Subject: RE: Attached letter from Kirklees Council regarding application number 2025/91147 at location George Hotel, St George's Square, Huddersfield, HD1 1JA

Bridges & Structures Manager
Structures Section
Highways and Streetscene
Kirklees Council

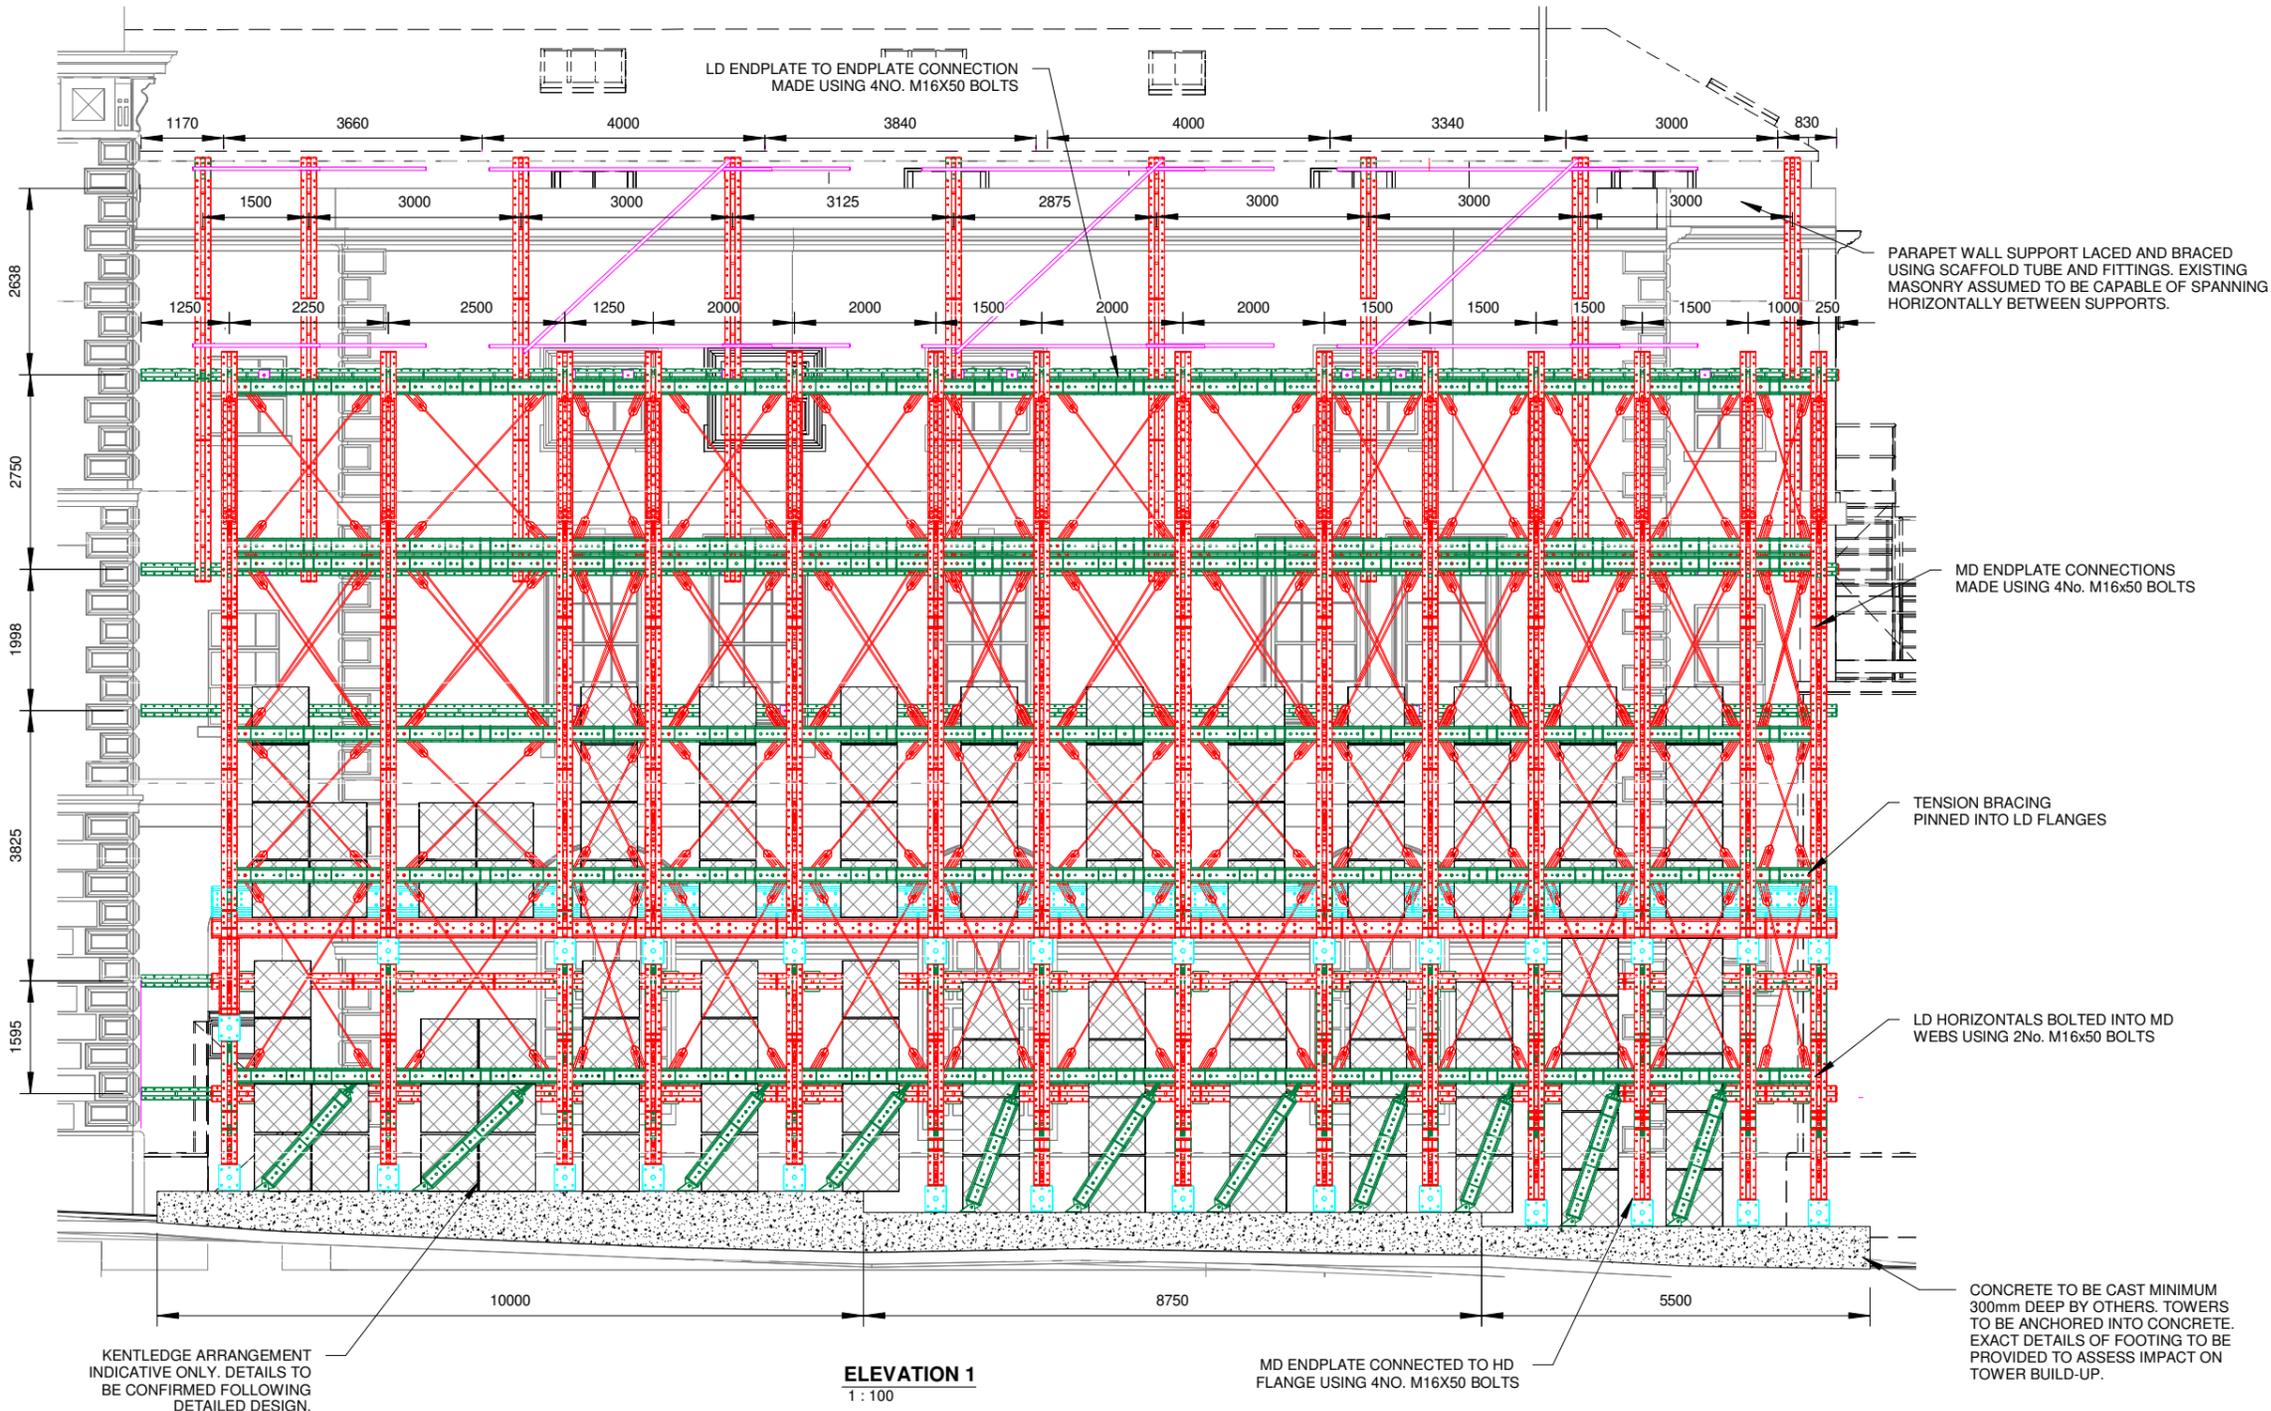
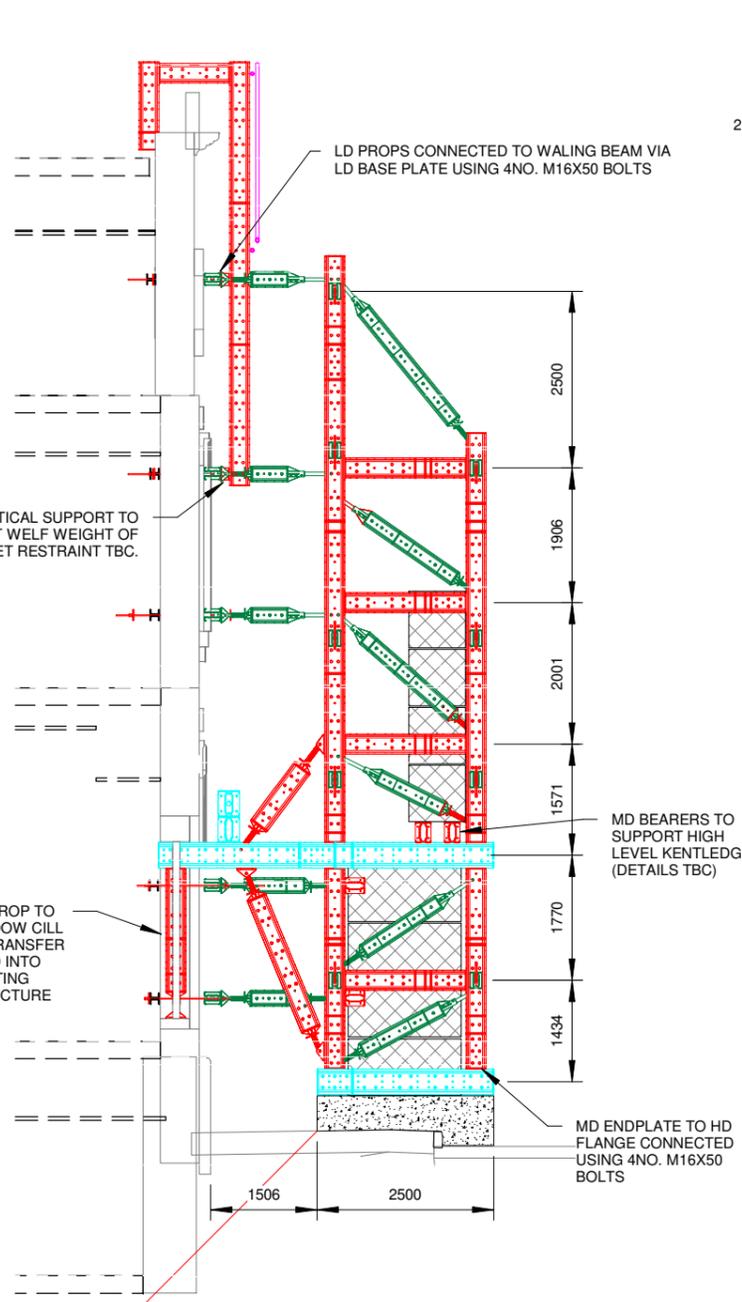
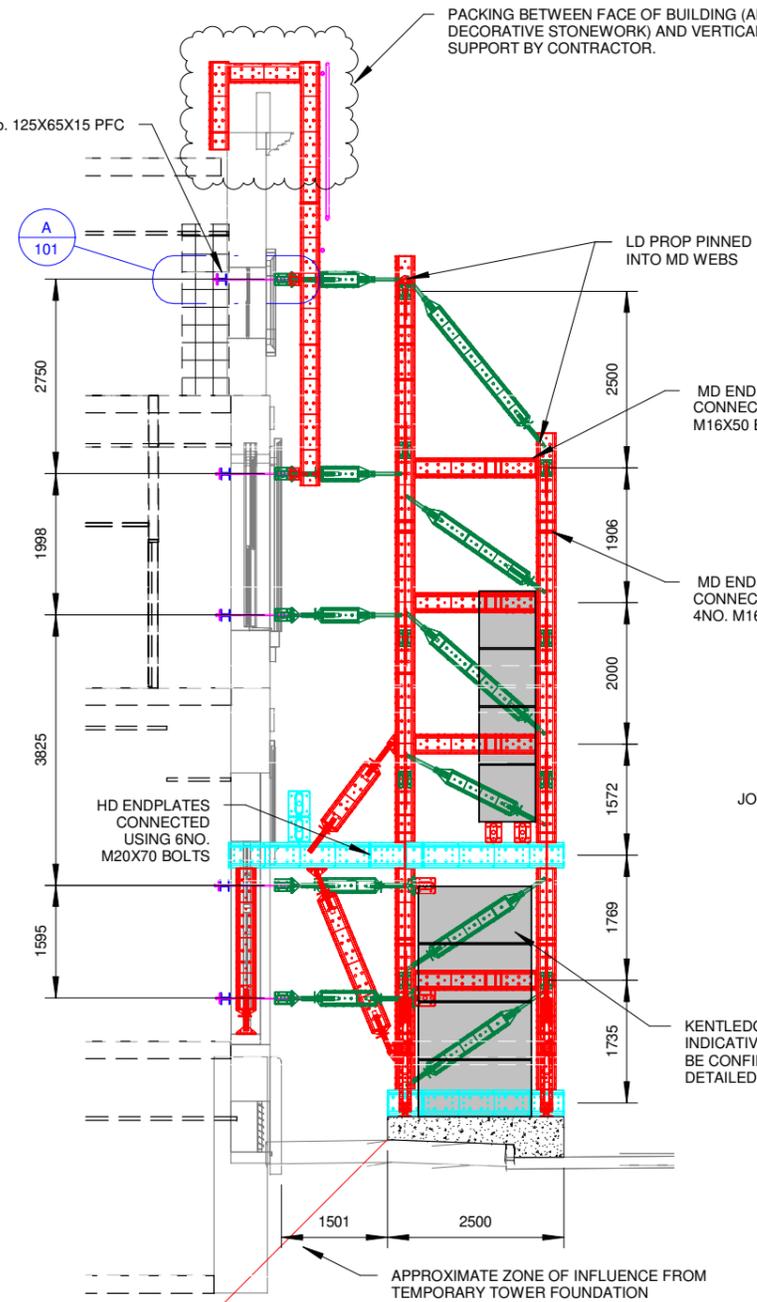
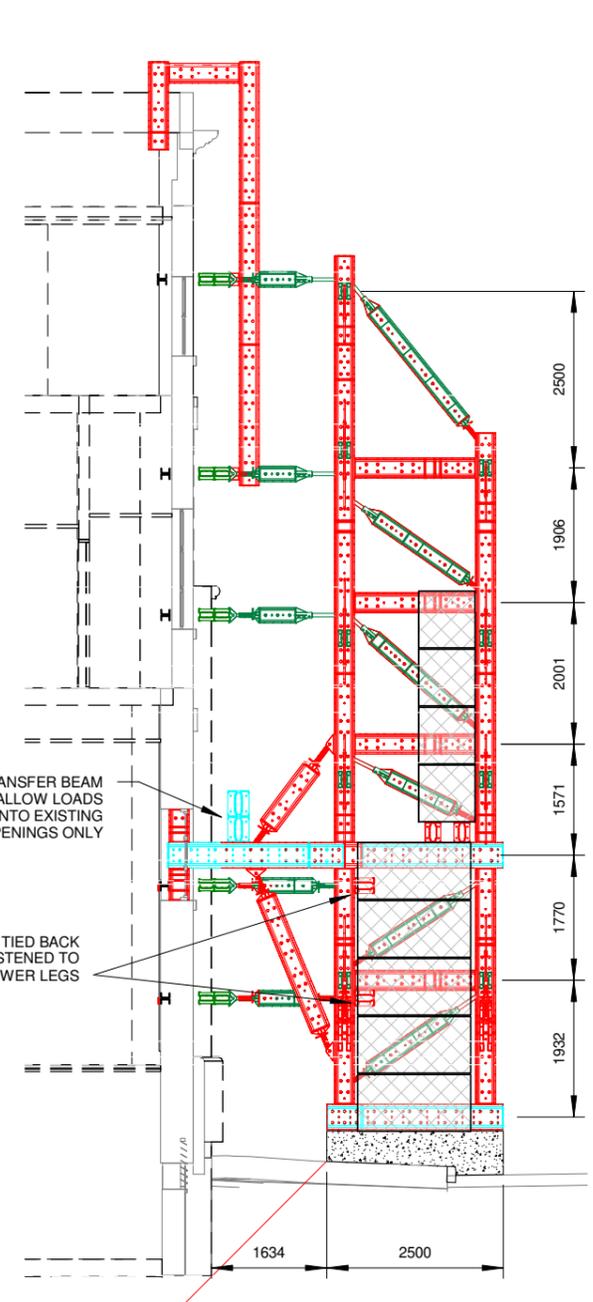
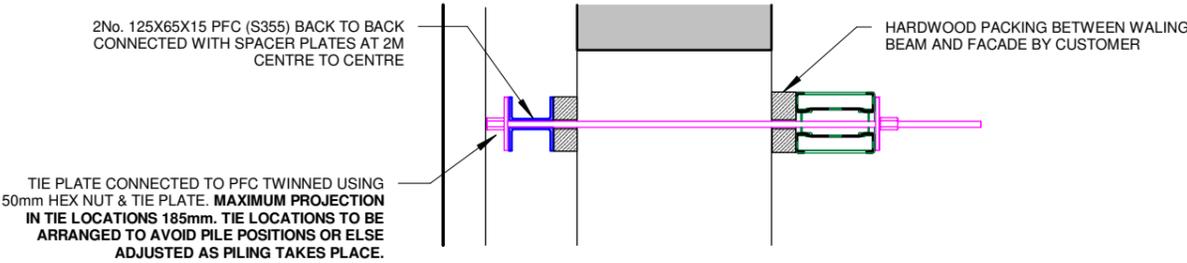
- 1) Before the development commences a scheme detailing the location and cross-sectional information including a method statement for the demolition of existing building walls supporting the adjoining adopted highway together with the design of any temporary works shall be submitted (via submission of an AIP) and approved by the Highway Authority in writing. The approved scheme shall be implemented prior to the commencement of the proposed development and thereafter retained during the life of the development.
